East Midlands Gateway Phase 2 – East Midlands Gateway Rail Freight Interchange Material Change - LCC responses to Examining Panel (ExP) first questions – Deadline 1 - 7th April 2026

East Midlands Gateway Phase 2 – East Midlands Gateway Rail Freight Interchange Material Change - LCC responses to Examining Panel (ExP) ISH1 Actions assigned to LCC – Deadline 1 - 7th April 2026

Connection from Diesworth Lane (which is closed to traffic, except for access) to EMG on a shared footway/cycleway. Throughout EMG there is a network of shared footway/cycleway routes which facilitate access to Kegworth

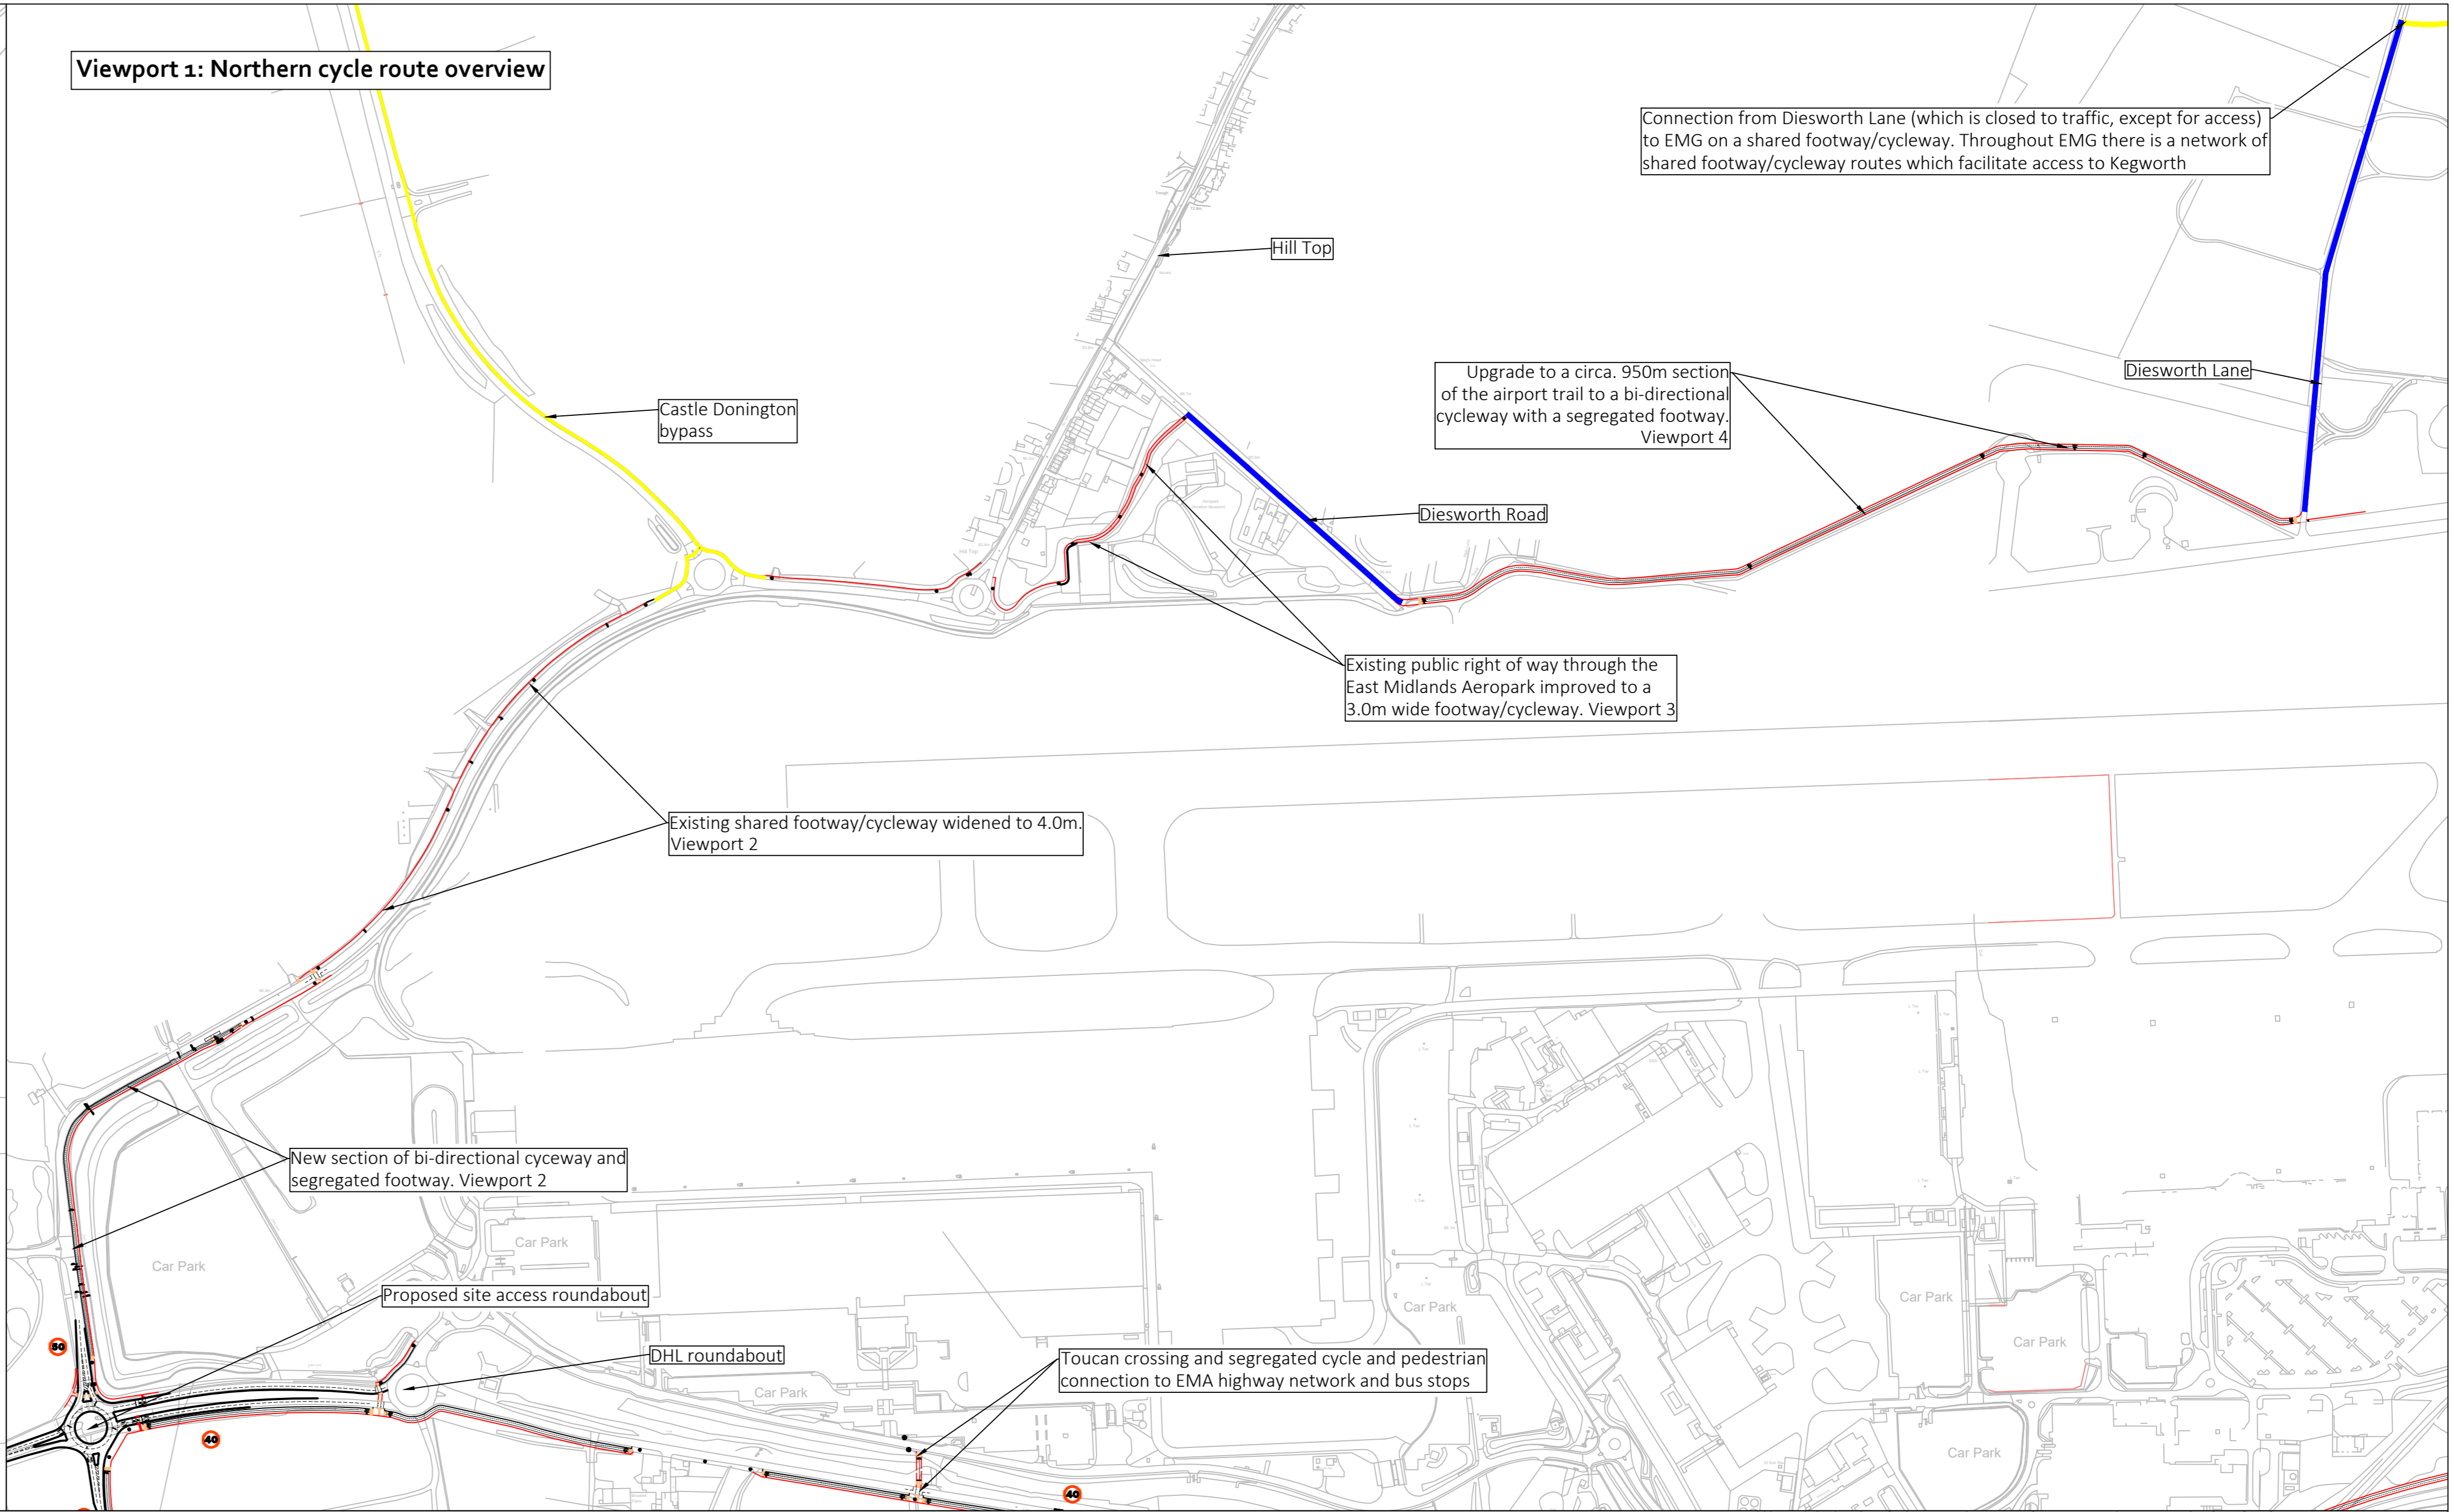
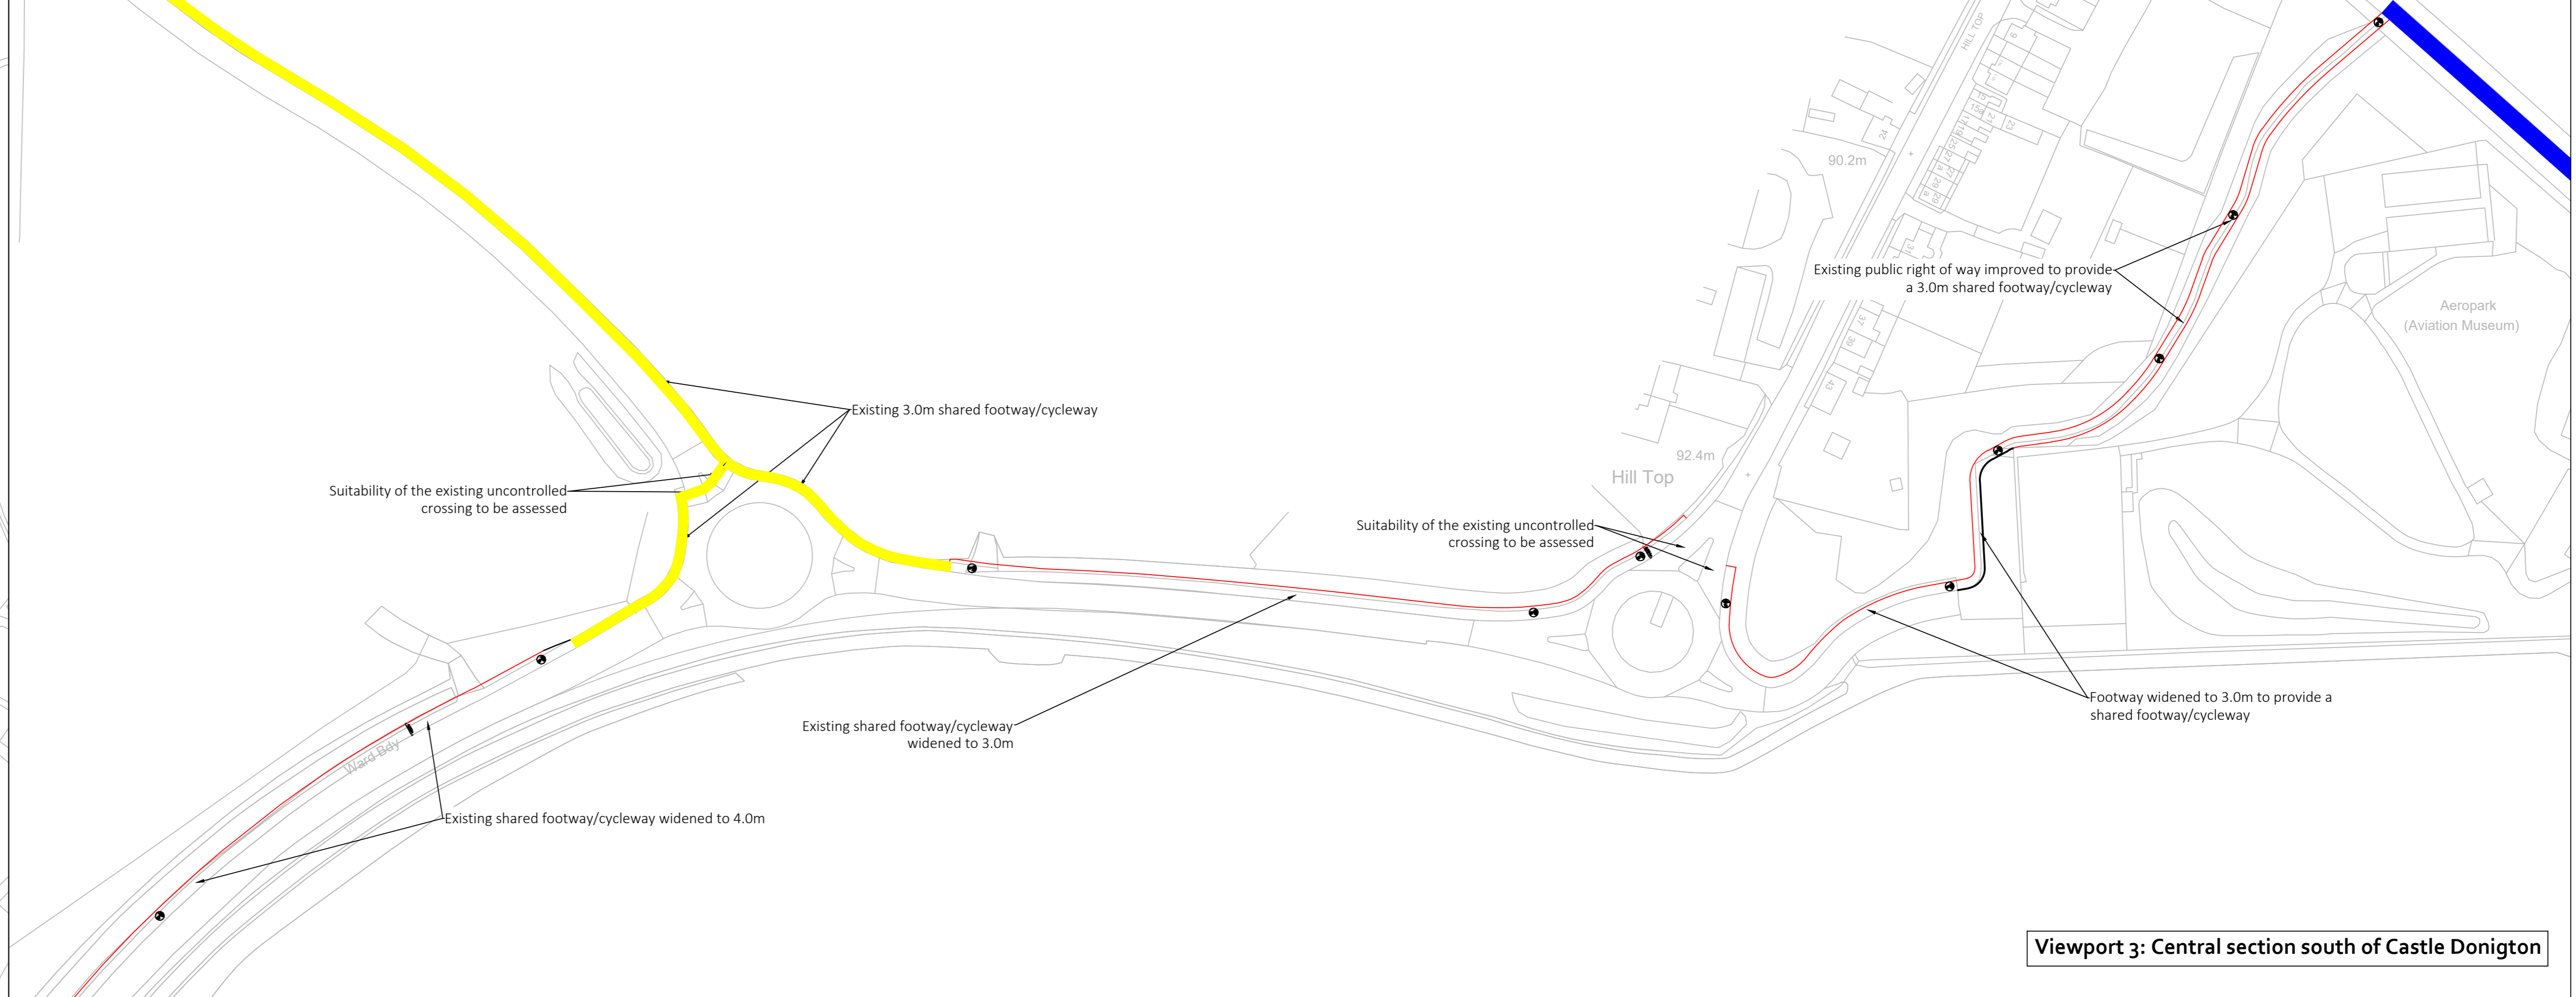
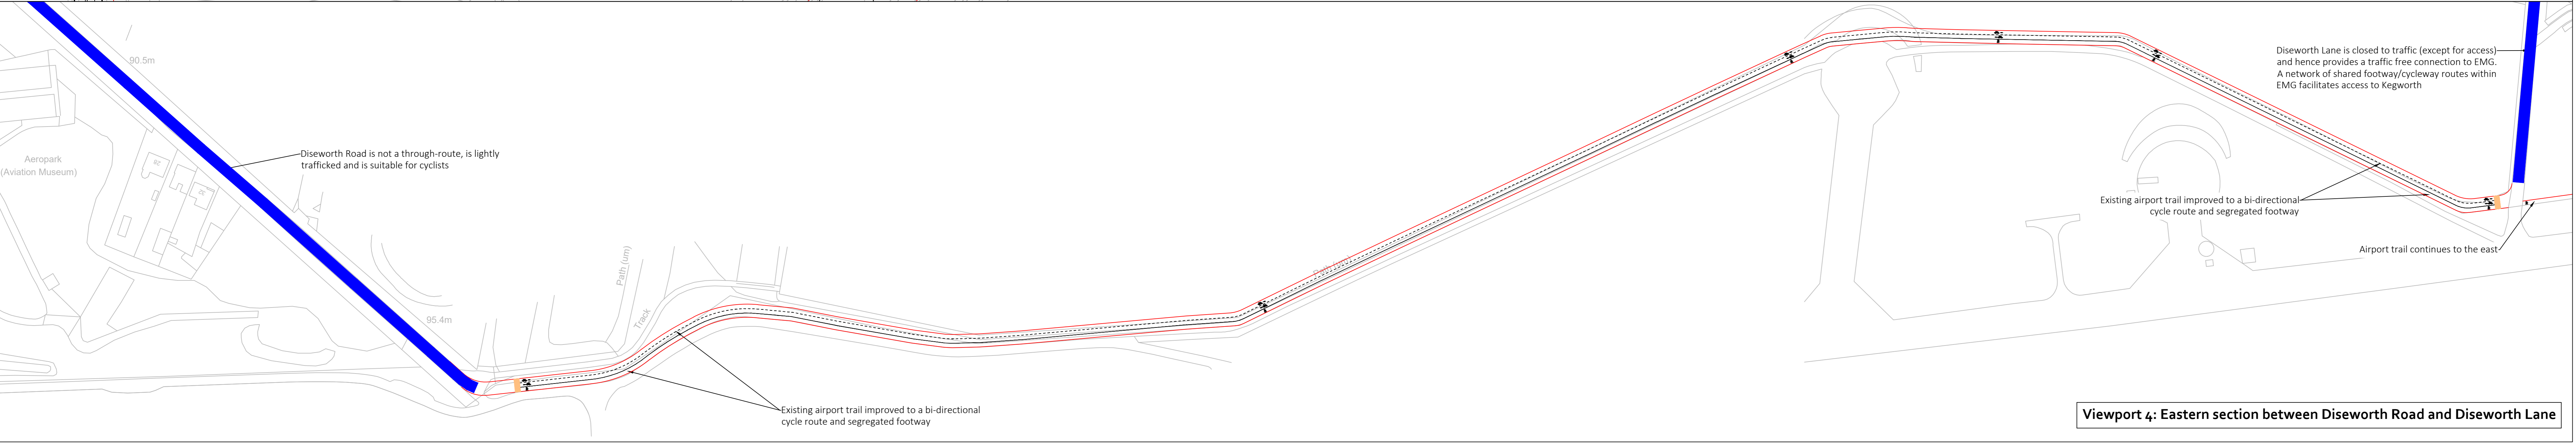
Q19.0.26	<p>Work No. 15</p> <ul style="list-style-type: none"> • Could the applicant's explain why the pedestrian access across the A453 would be an uncontrolled crossing rather than integrated into the existing junction as a controlled crossing? • Could LCC and NWLDC comment on the proposition that this should be so integrated. • Would this have any implications for the traffic modelling. 	<p>The Applicant has proposed a new PRoW (points 10 to 11) [APP-037D] and a short section of footway directing pedestrians to cross the A453 at the signal-controlled junction for East Midlands Airport. However, this signal-controlled junction has no pedestrian provision.</p> <p>Moreover, neither a detailed design, assessment, or Road Safety Audit (RSA) appear to have been produced by the Applicant for this crossing point. The appropriateness of the crossing should be determined via an assessment based on Traffic Signs Manual Chapter 6 guidance available at: (https://assets.publishing.service.gov.uk/media/5df0e29fed915d15f42c4820/dft-traffic-signs-manual-chapter-6.pdf) and a comprehensive package of information submitted to the Examination. LCC reserves the right to comment further on the safety and suitability of this crossing provision.</p>
